**RE: Sea Link (EN020026) Nationally Significant Infrastructure Project (NSIP) Application – Written post hearing submissions including written summaries of oral cases made at hearings the w/c 26 January 2026 (Deadline 4) – Kent Wildlife Trust [REDACTED]**

### **Issue Specific Hearing 2 – Environmental Matters**

Legend

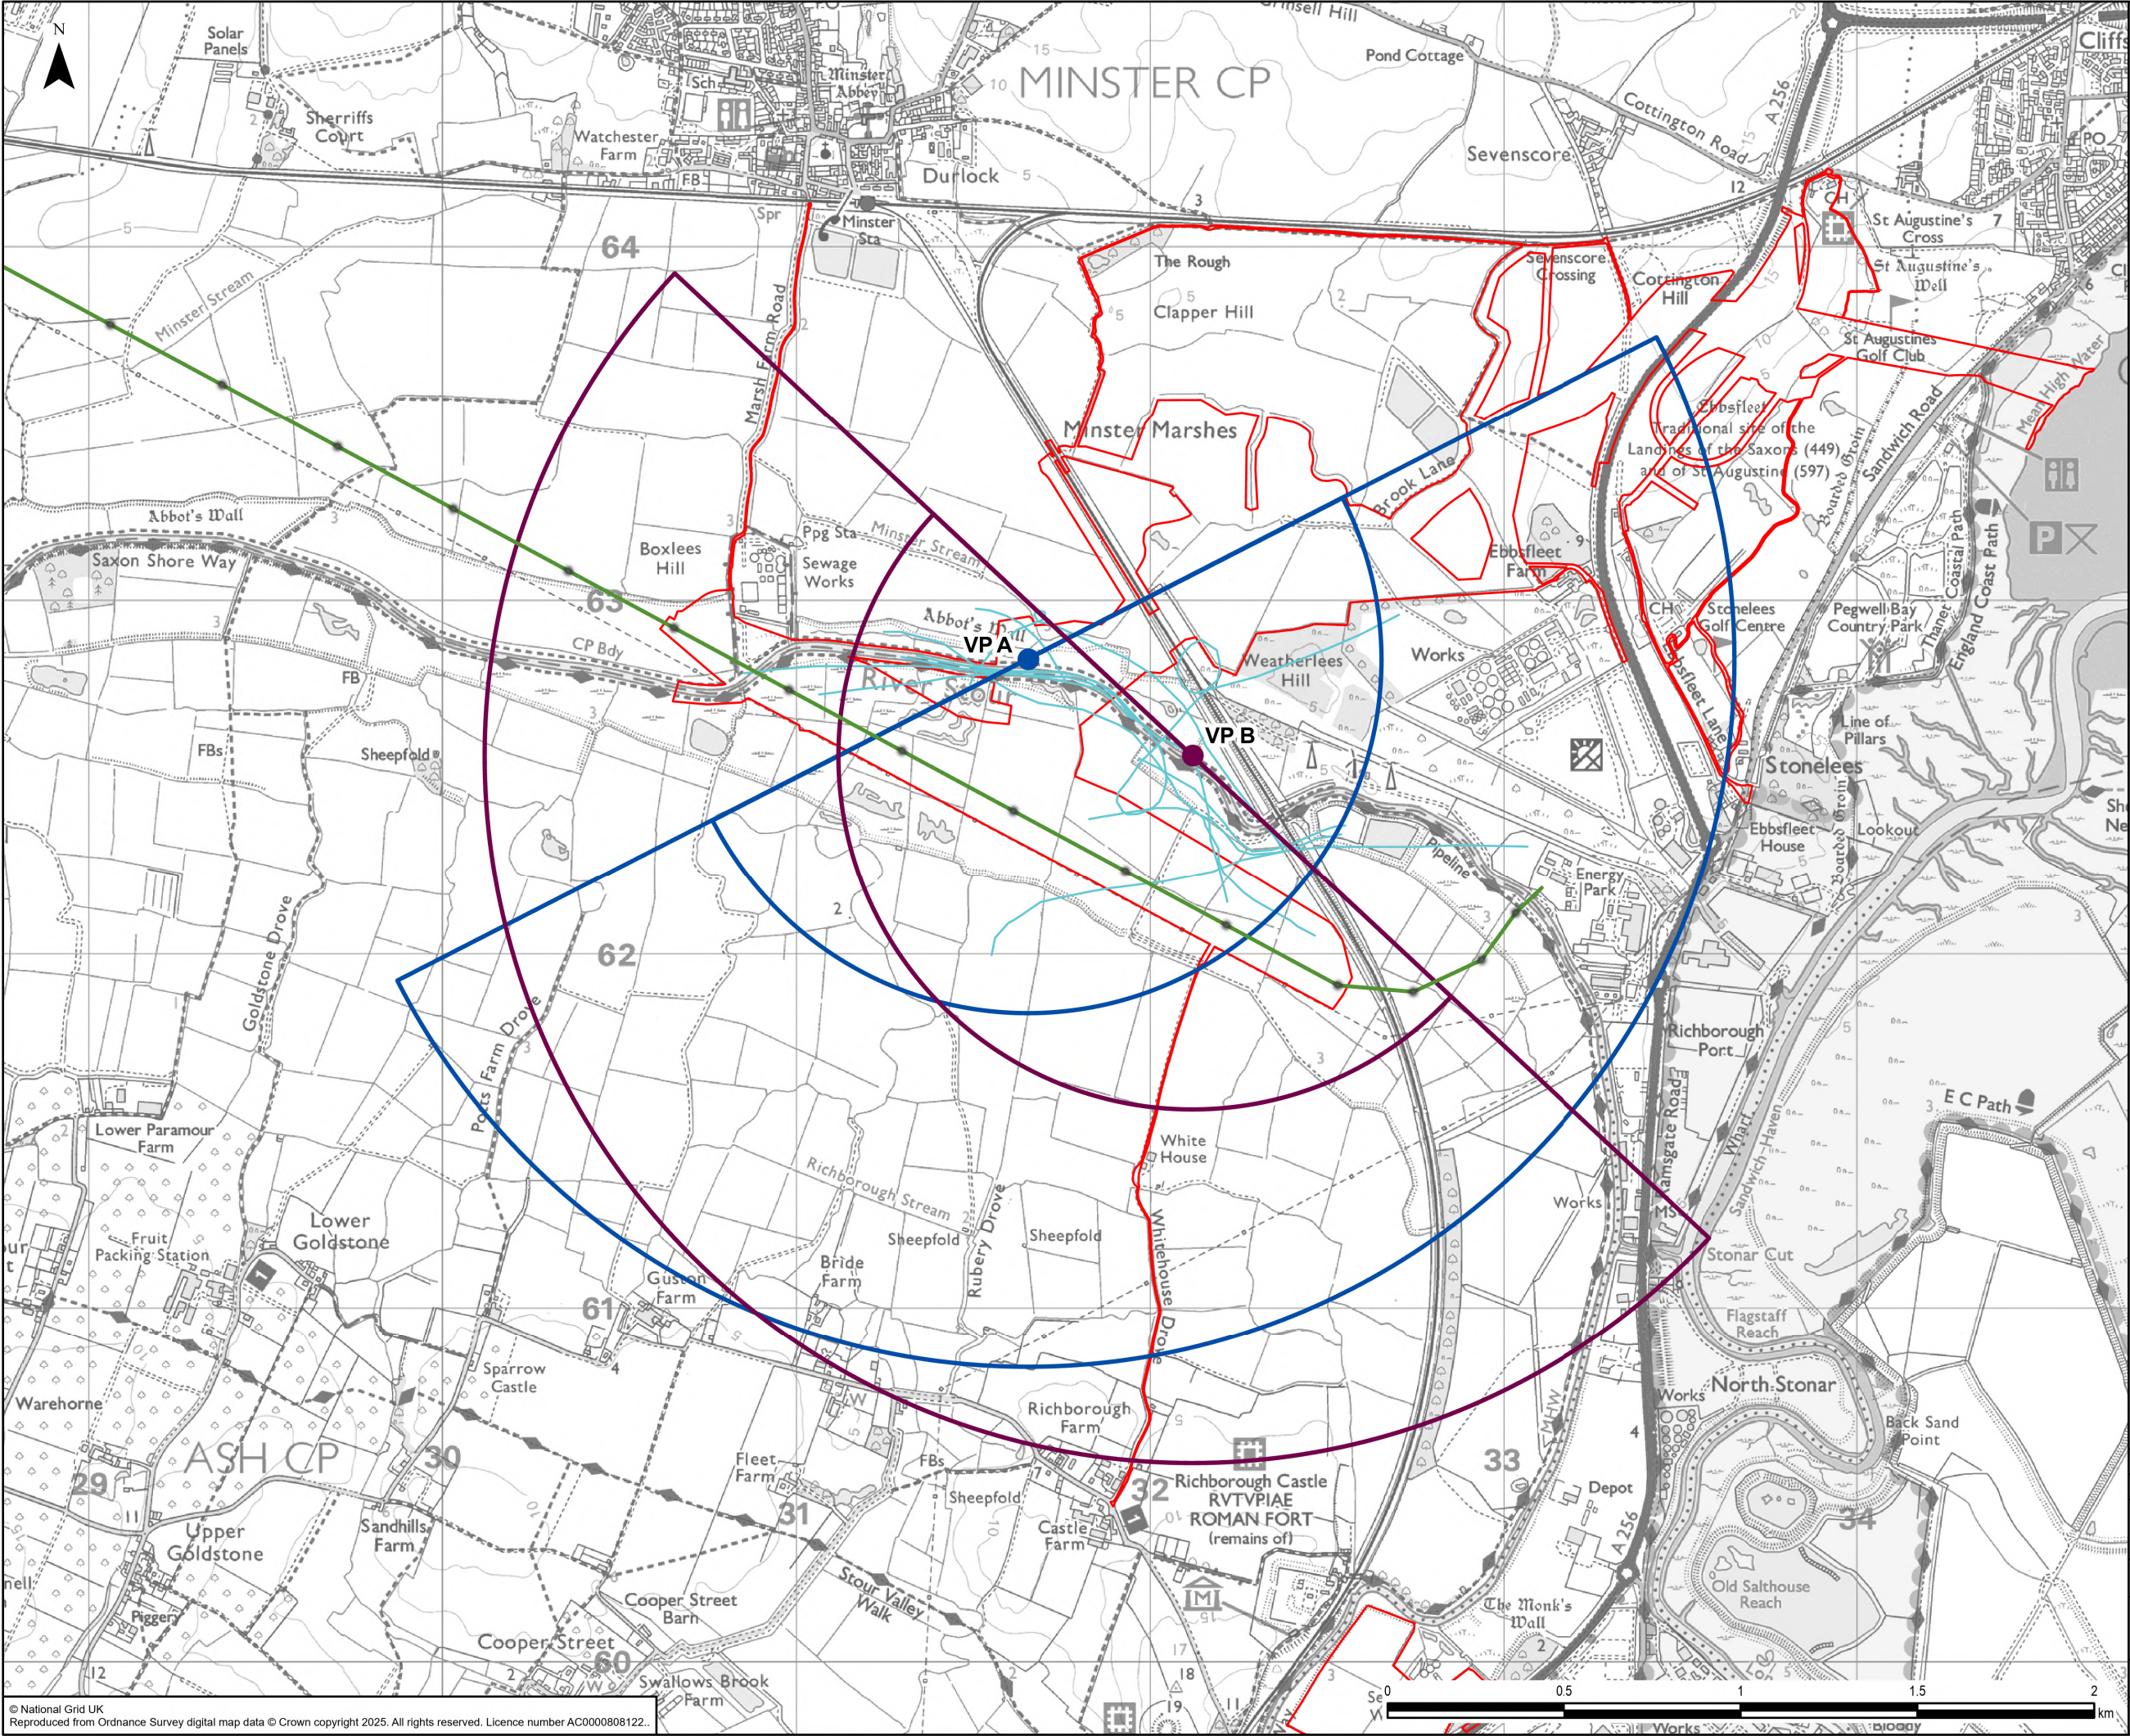
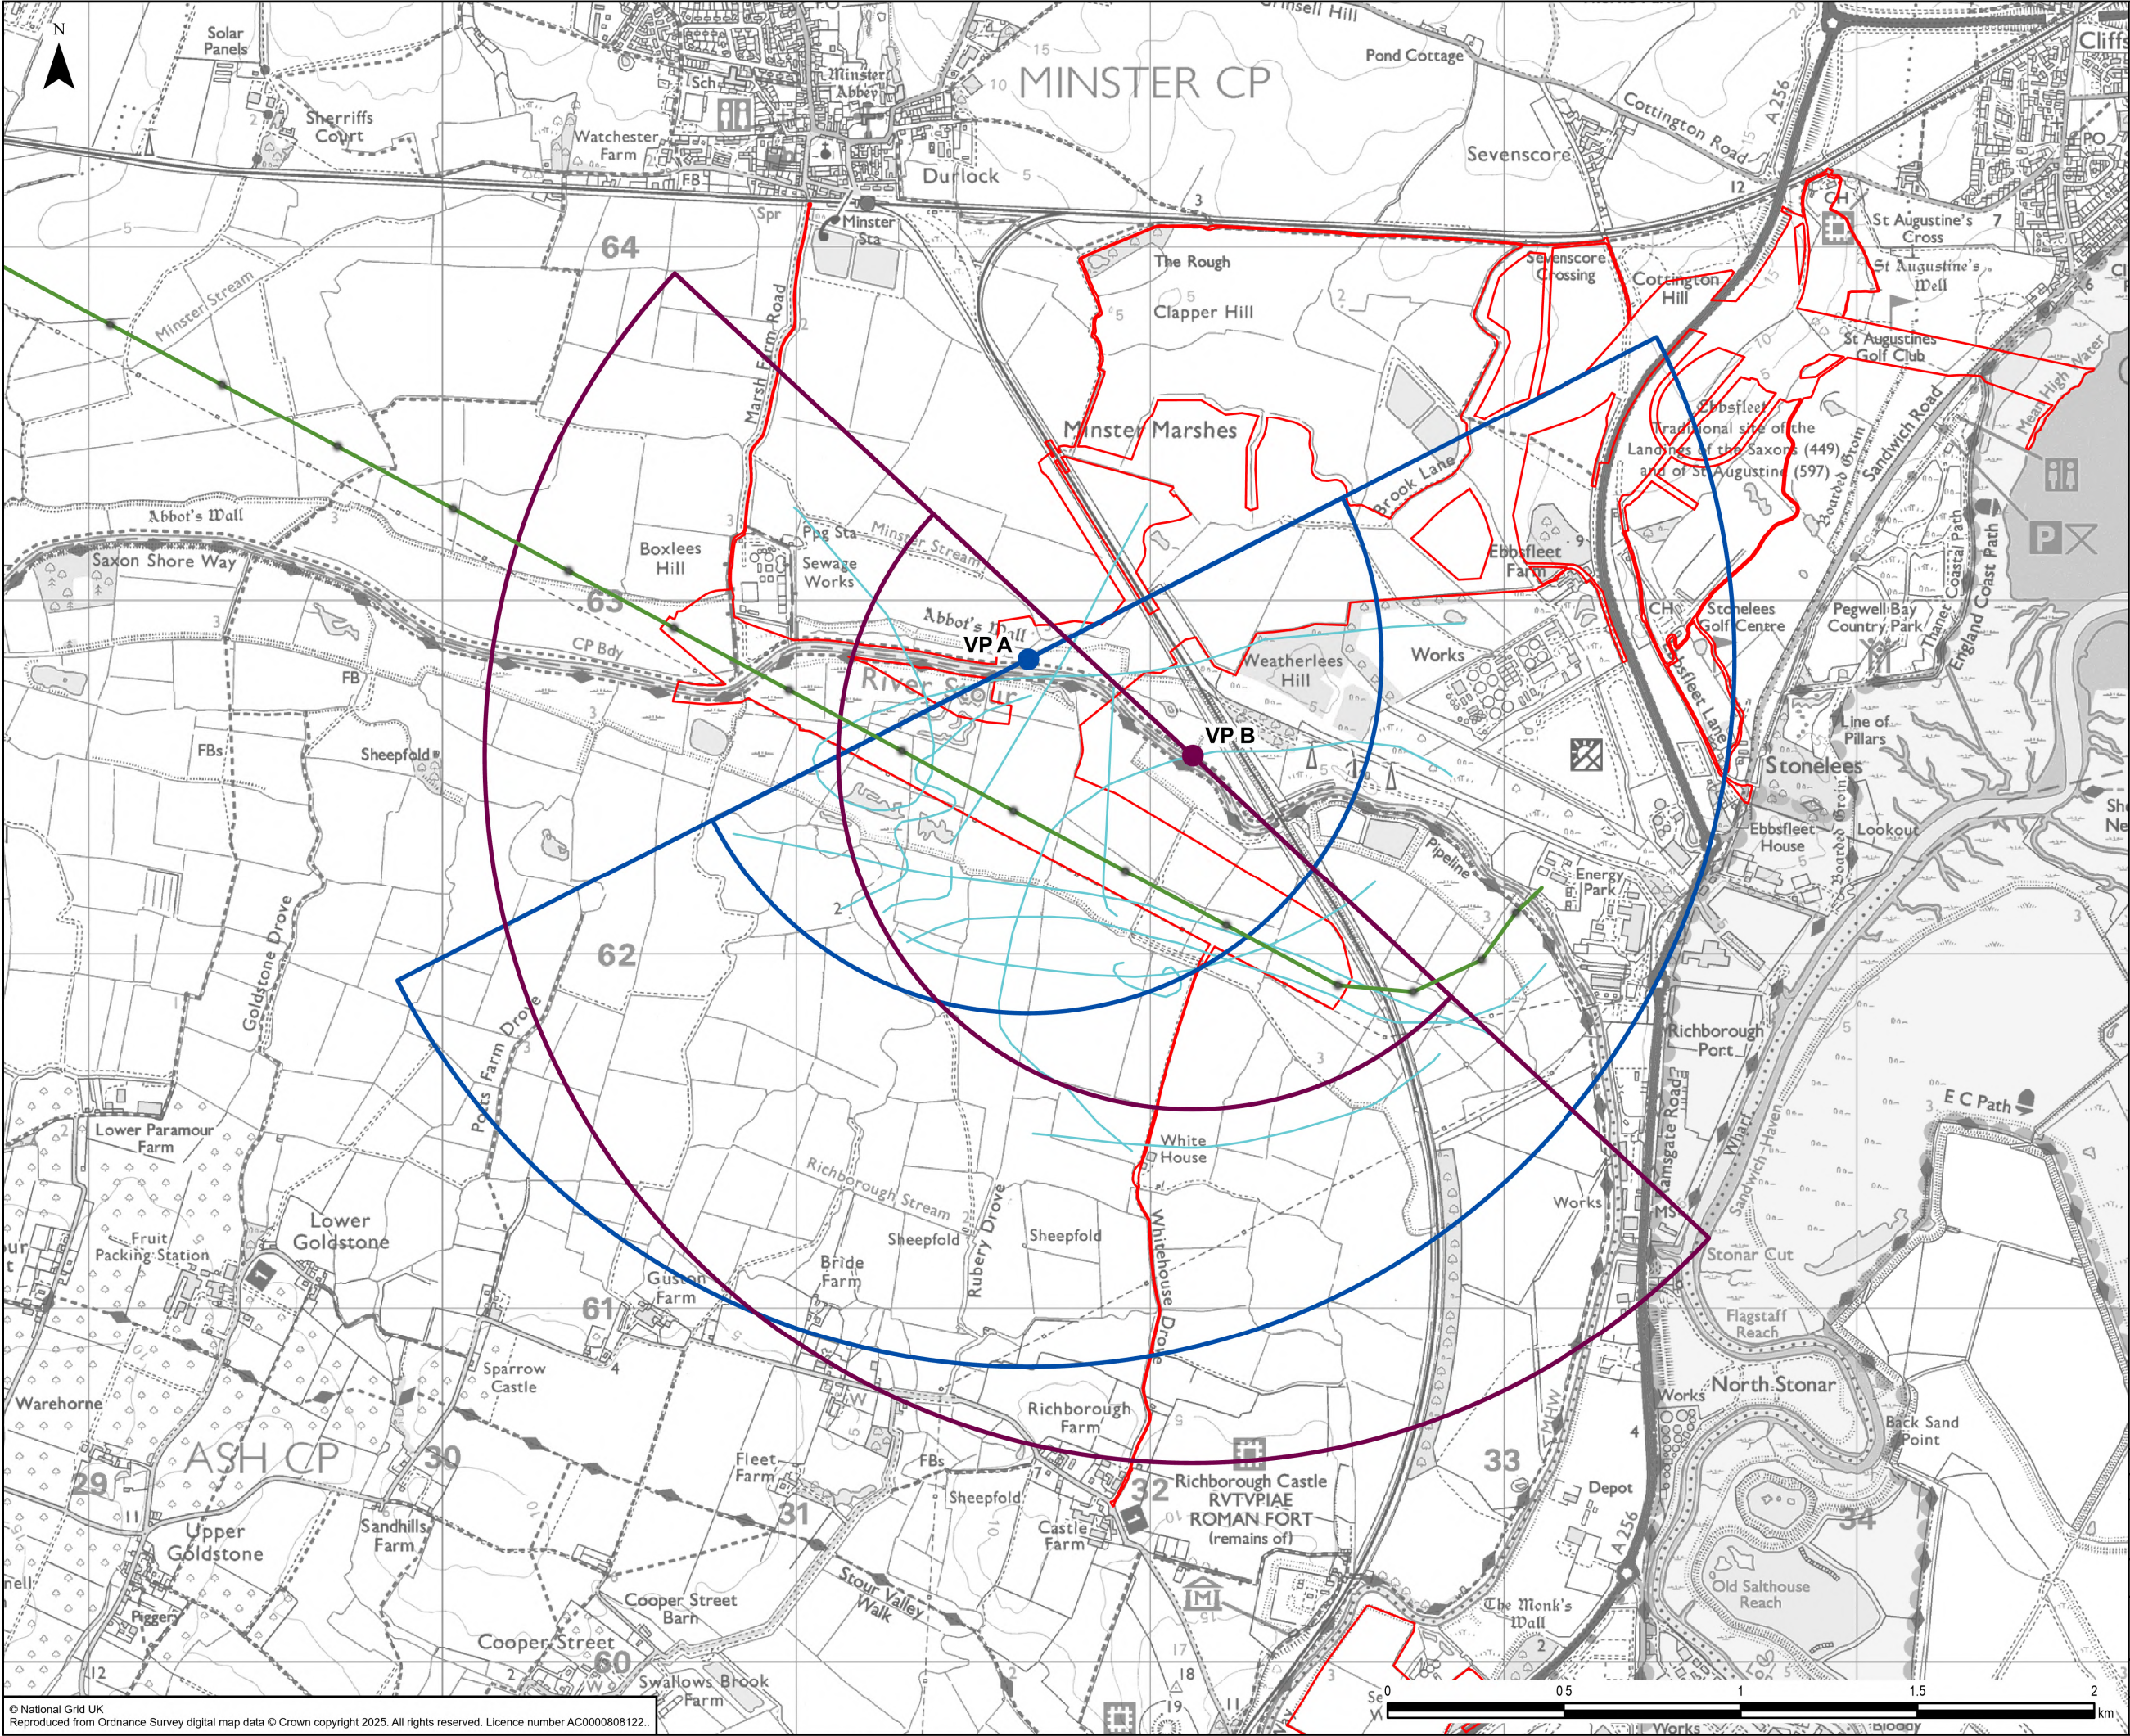
At ISH2, the Applicant's position was that collision risk with the proposed overhead lines (“OHL”) would be limited because birds are already habituated to existing lines in the area, with most species flying over the cables and some smaller species flying underneath. The Applicant stated that this conclusion was informed by vantage point surveys of flight paths. However, KWT considers that this reliance on existing habituation is insufficient, particularly given that the introduction of new lines into an already complex “wirescape” could alter existing flight behaviour and collision risk, a matter which remains untested and unresolved.

KWT disagrees with the Applicant's statement that bird diverters are not needed on the existing lines because birds are already taking avoidance action. The introduction of additional overhead lines has

the potential to change established flight patterns and avoidance behaviour, with birds displaced from the new cables potentially being funnelled into, or diverted towards, existing lines, thereby increasing rather than reducing collision risk across the wider wirescape.

Since ISH2 and listening to the Applicant's response about how the proposed bird diverters for new OHL work (absorbing light during the day and emit it at night), KWT have undertaken preliminary research into the proposed diverters. Research indicates that such devices require sustained sunlight with a UV Index of at least 3 to function effectively. During periods of heavy cloud cover, or when the UV Index drops to 1 or below, their effectiveness is significantly reduced or nullified. Notably, the UV Index at Pegwell Bay during the three days of ISH2 peaked at only 0.7, well below the minimum threshold, raising serious doubts about their efficacy during winter or overcast conditions, when collision risk may remain high. KWT shared these findings and concerns with Kent Ornithological Society ("KOS"), who raised further concerns that there is little scientific evidence demonstrating the effectiveness of these specific fluorescent deterrents. **Therefore, we pose the following question to the Applicant:**

Can the Applicant confirm whether the proposed fluorescent bird deterrents have been used elsewhere on comparable overhead line projects, including whether they have been used for other National Grid projects, and if so, provide details of their history of use, relevant case studies, and any monitoring or evidence demonstrating their effectiveness in reducing bird collision risk.
